CITY OF PORTLAND

BUILDING PERMIT

Located At 45 TIDE MILL RD

Job ID: 2012-05-4074-SF

EXISTING CONDITIONS PLAN
 OF: **DAWSON PROPERTY**
 45 TIDE MILL ROAD
 PORTLAND, MAINE
 FOR: **CLOUTIER CONSTRUCTION INC.**
 49 EASTMAN ROAD
 CAPE ELIZABETH, MAINE 04107

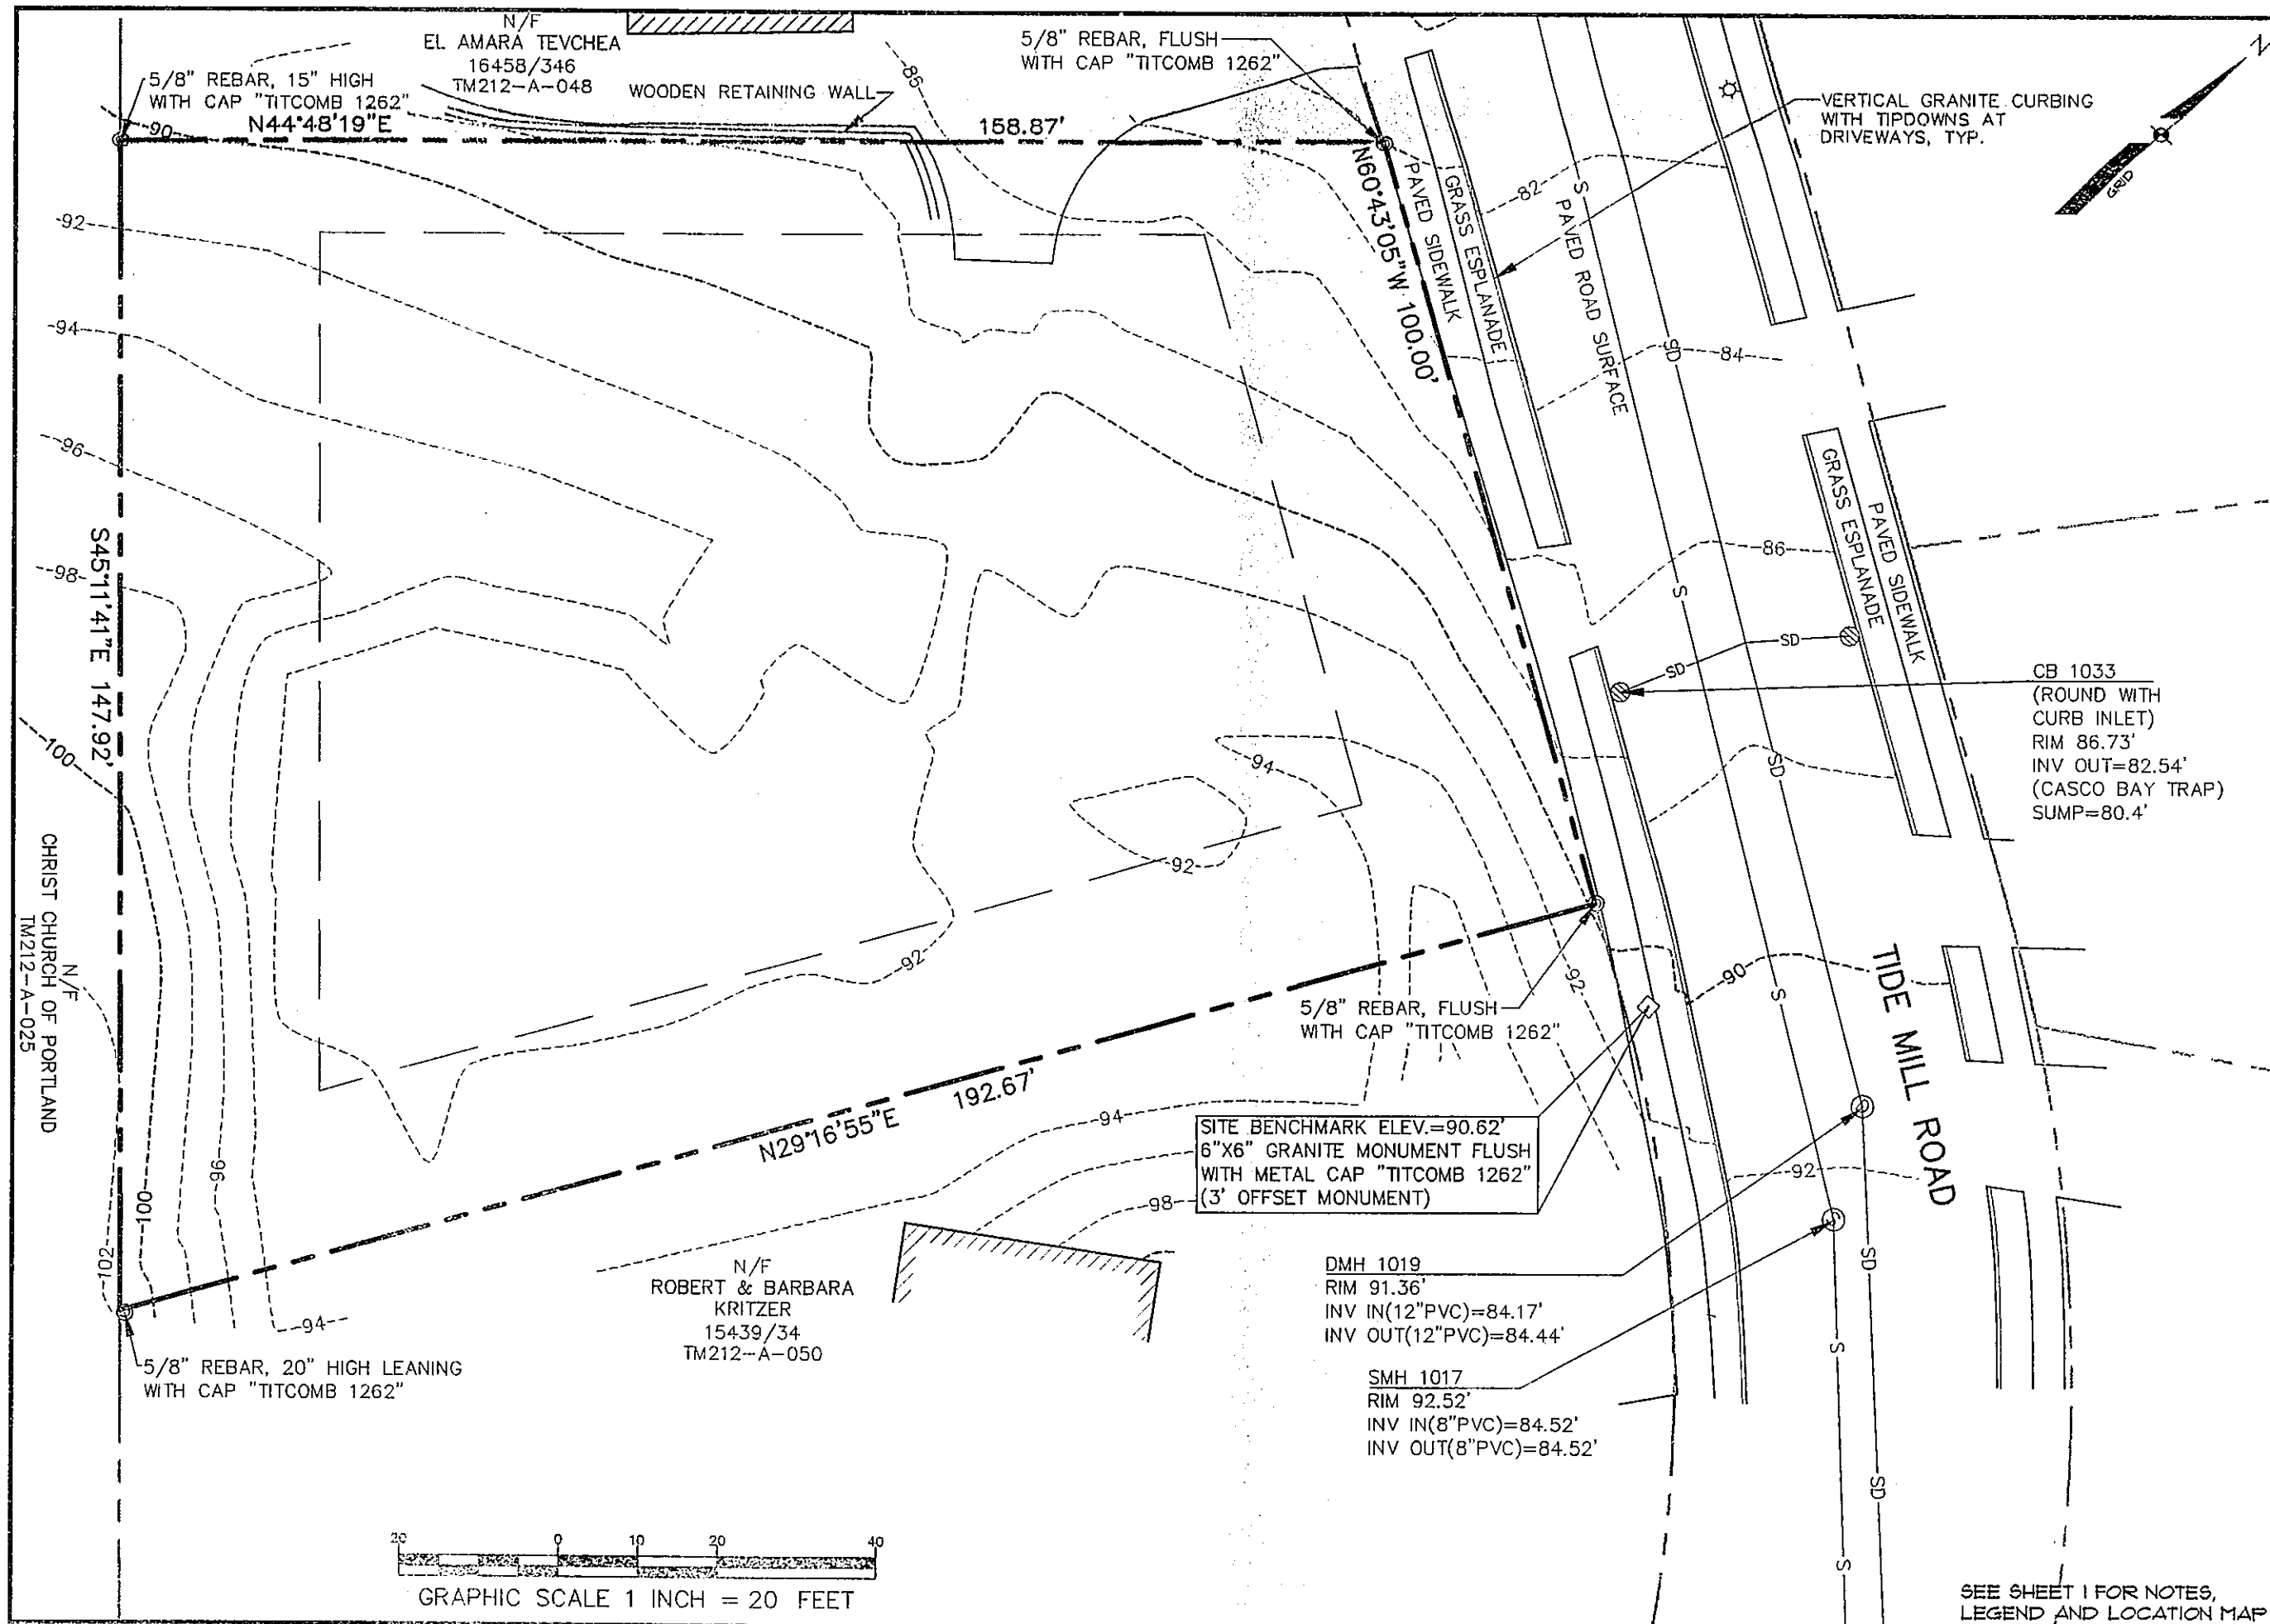
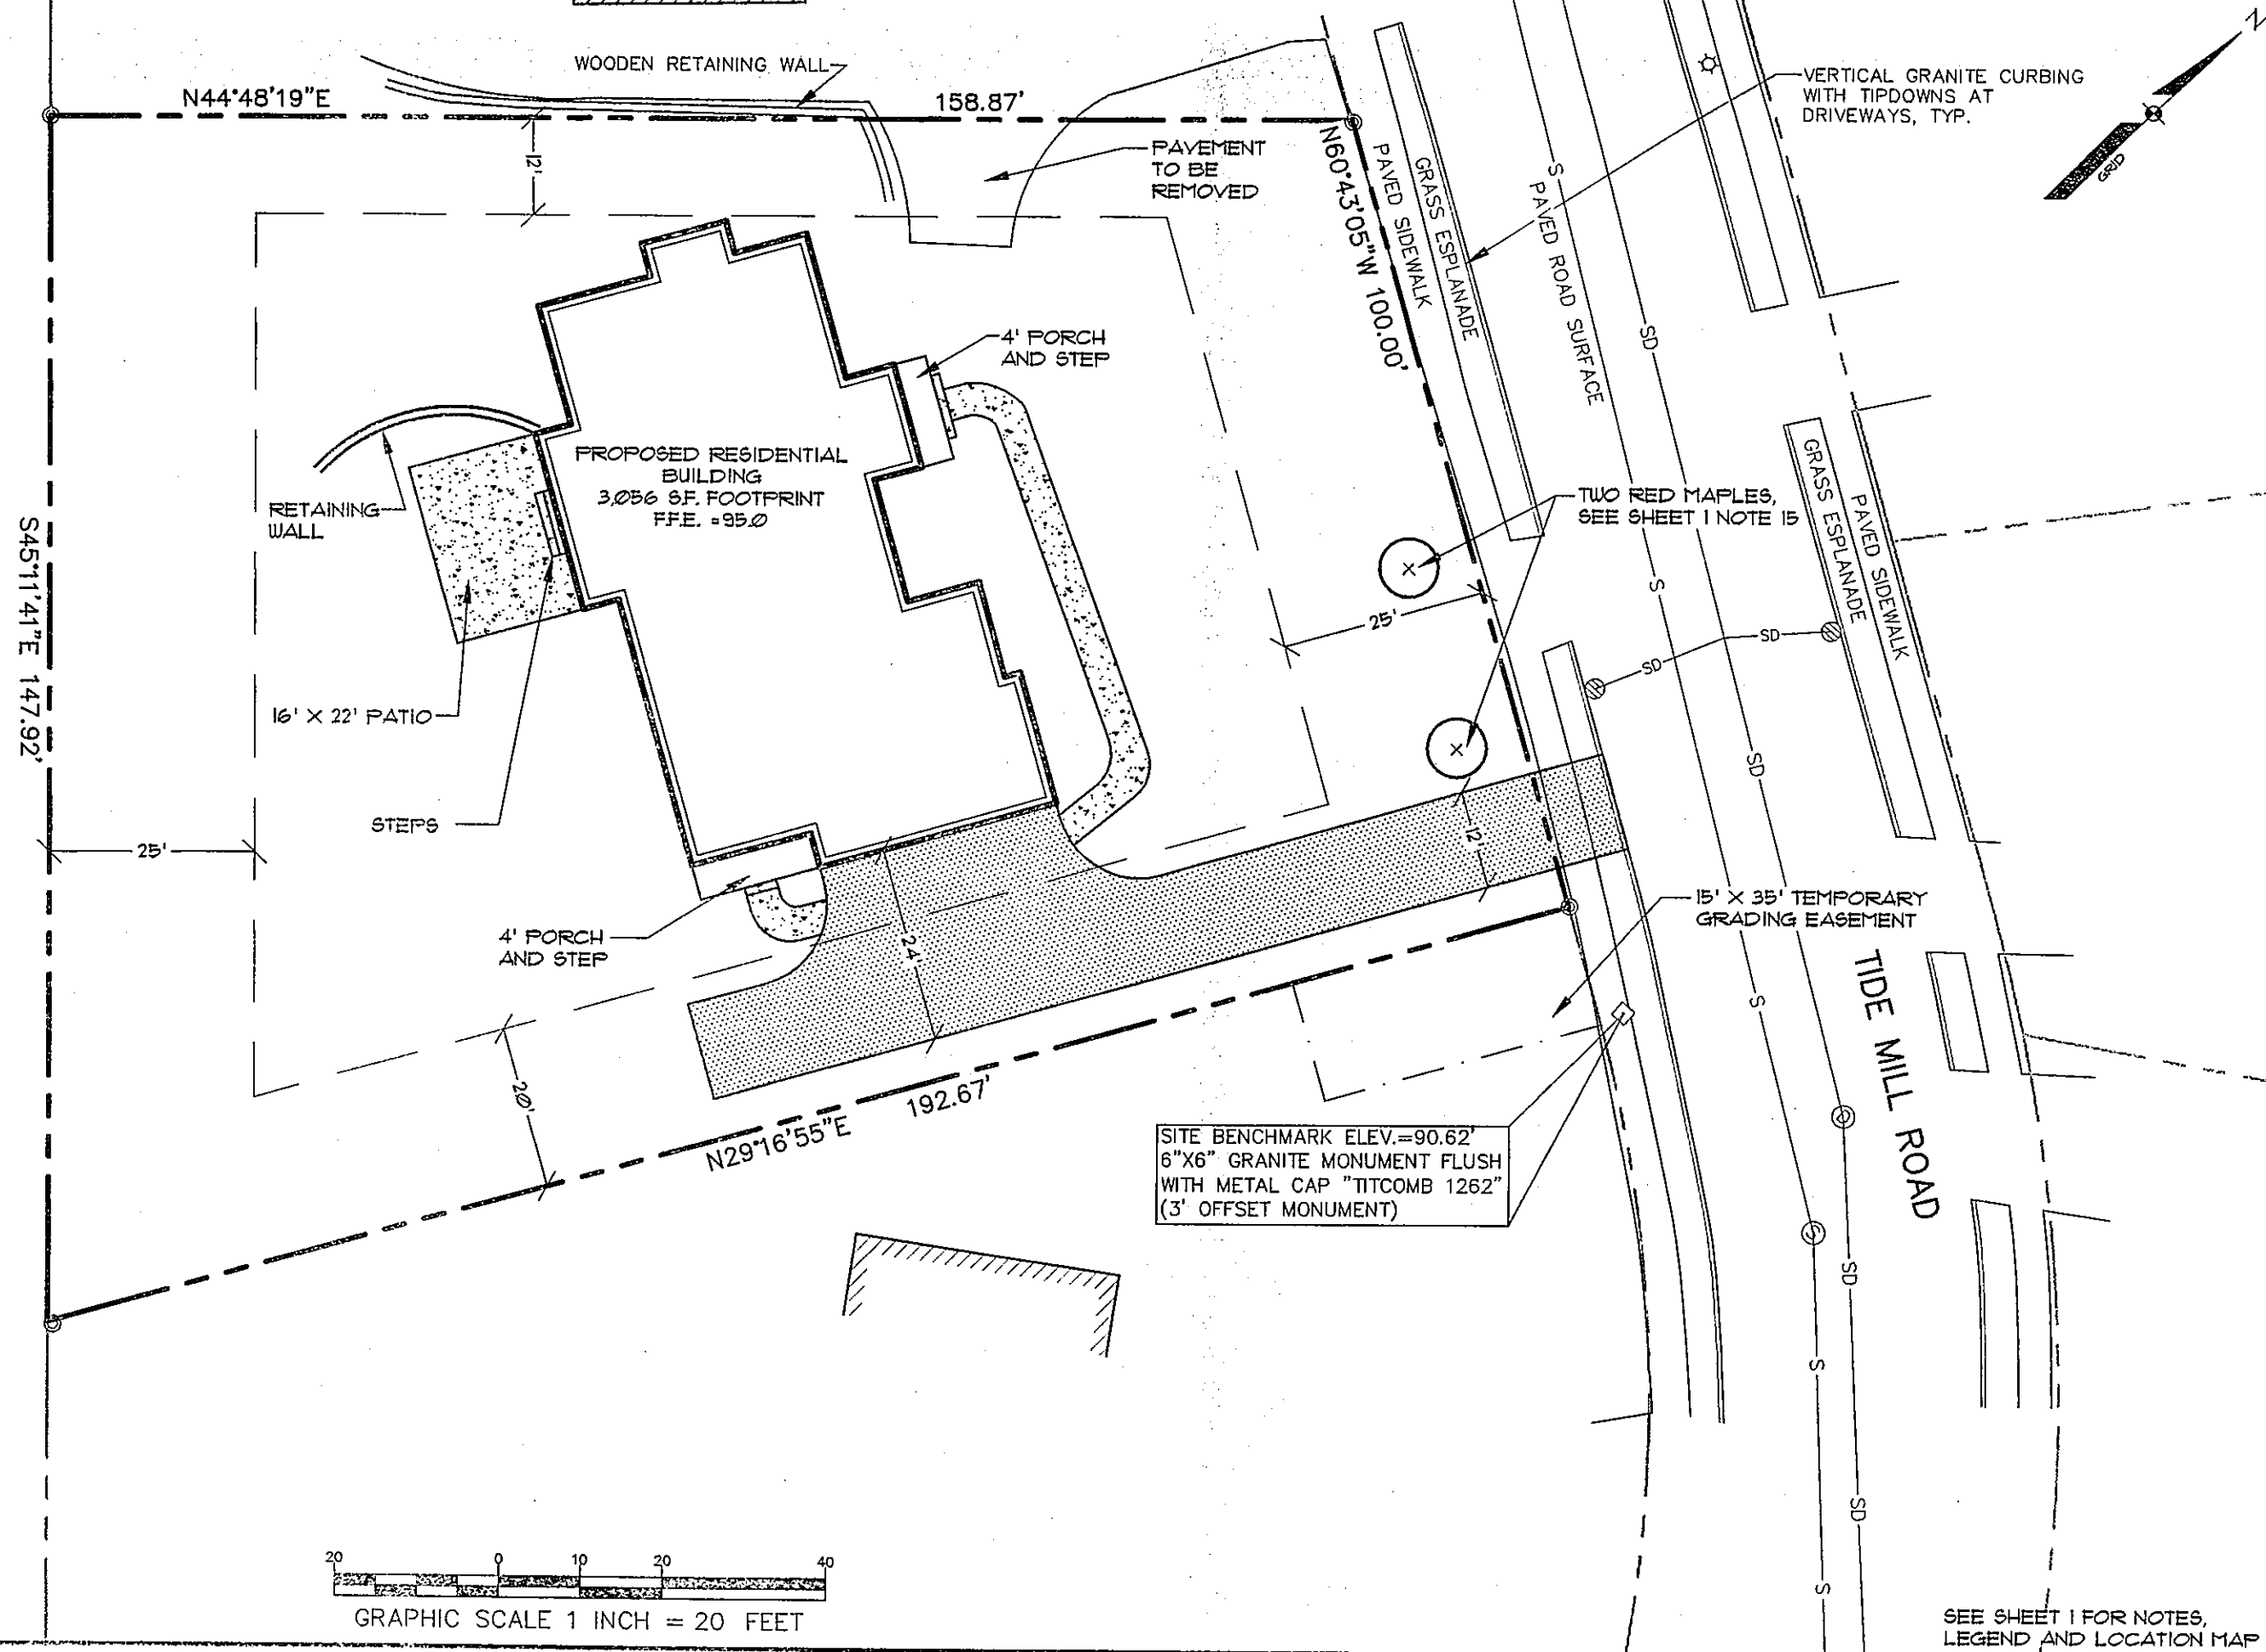
12. Prior to the construction of the retaining wall, a detail of the wall must be submitted for review and approval by the Planning Department. The wall may have to be designed and stamped by an engineer, and include plans and details.
